ISSUED: 09.19.2024  
**LANDSCAPE PLAN**  
SHEET 6 OF 8

UDON SOUTH - PCD FILE # PPR2422

# V\_3 Landscape Plan Redline Return.pdf Markup Summary

CO STATE HIGHWAY 94
(100' PUBLIC RIGHT-OF-WAY)
(REC. NO. 219151478)

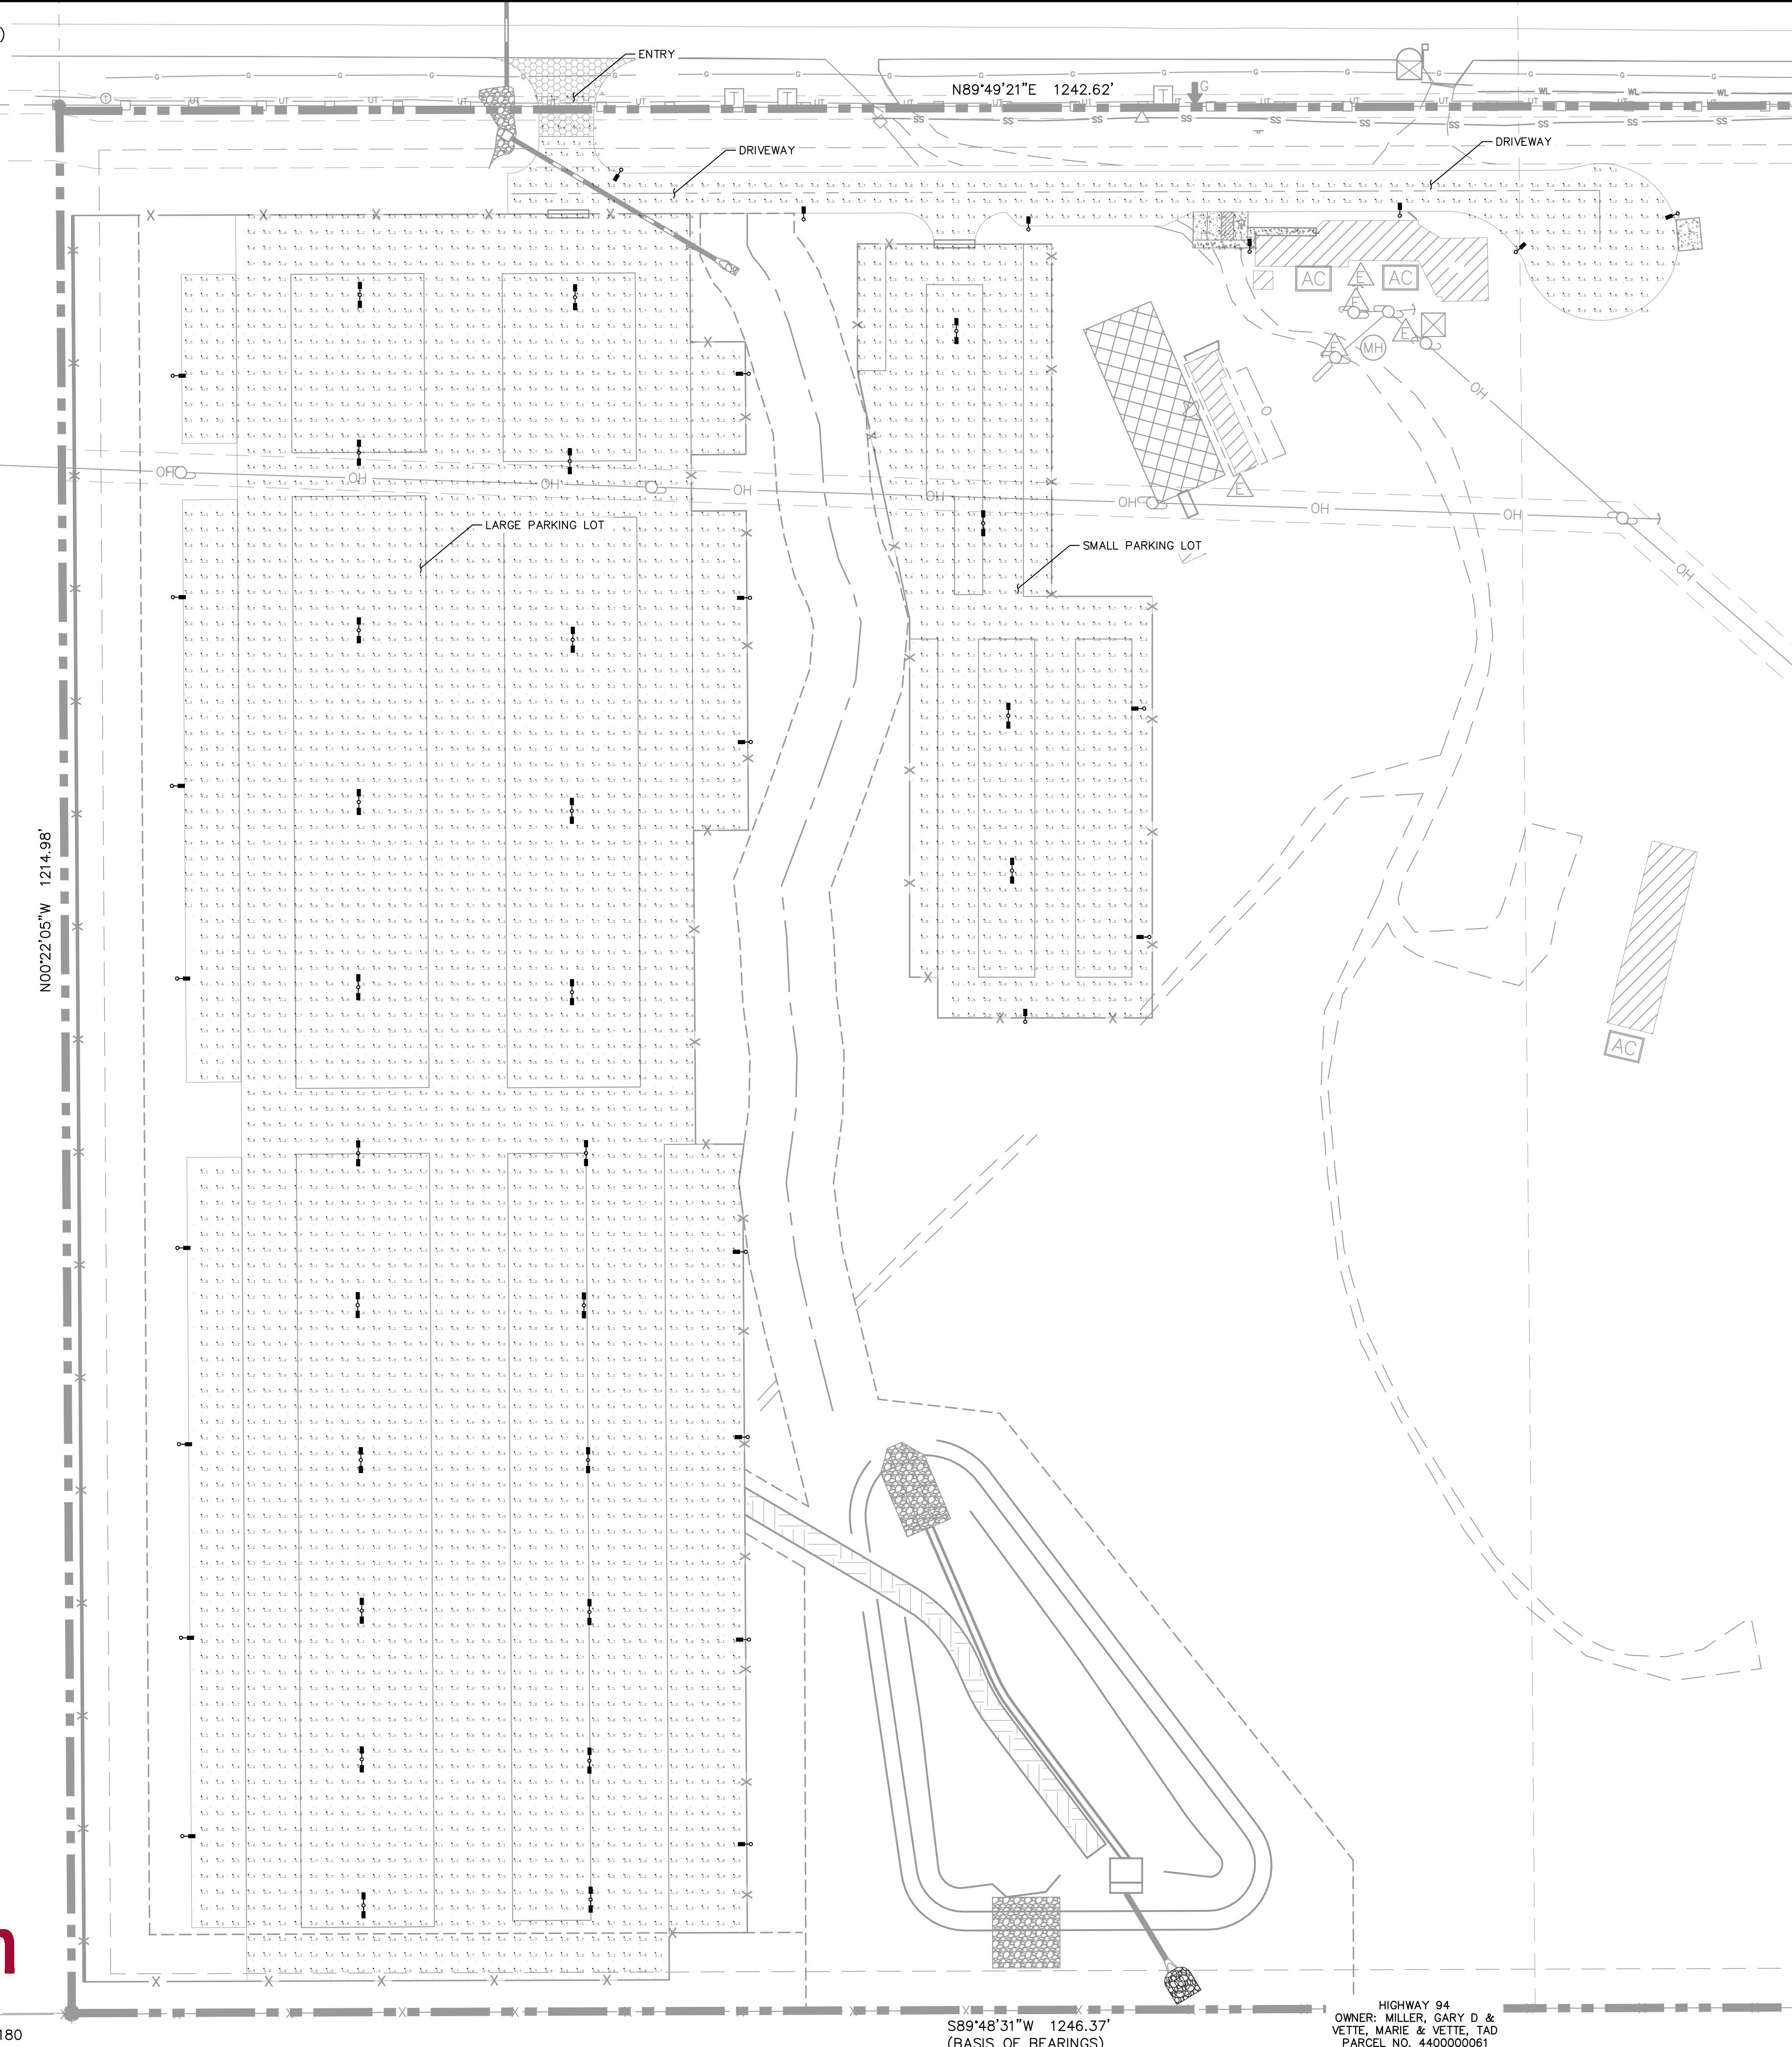
Per previous comment:  
 Required roadway trees = 62  
 Provided roadway trees = 41

Add an additional 21 trees to the 25' roadway tree area.

Per previous comment:  
 Minimum 1/3 evergreen for roadway trees.  
 Use at least 21 evergreens as roadway trees.

As mentioned on both previous versions, refer to §6.2.2.D.2

South and West Buffer minimum 15' deep, 1 tree per 25' (1/3 evergreen), all buffer area must have ground cover

1,244/25=49.76=50  
Minimum 50 south buffer trees  
Provided 45

1,149/25= 45.96=46  
Minimum 46 west buffer trees  
Provided 44
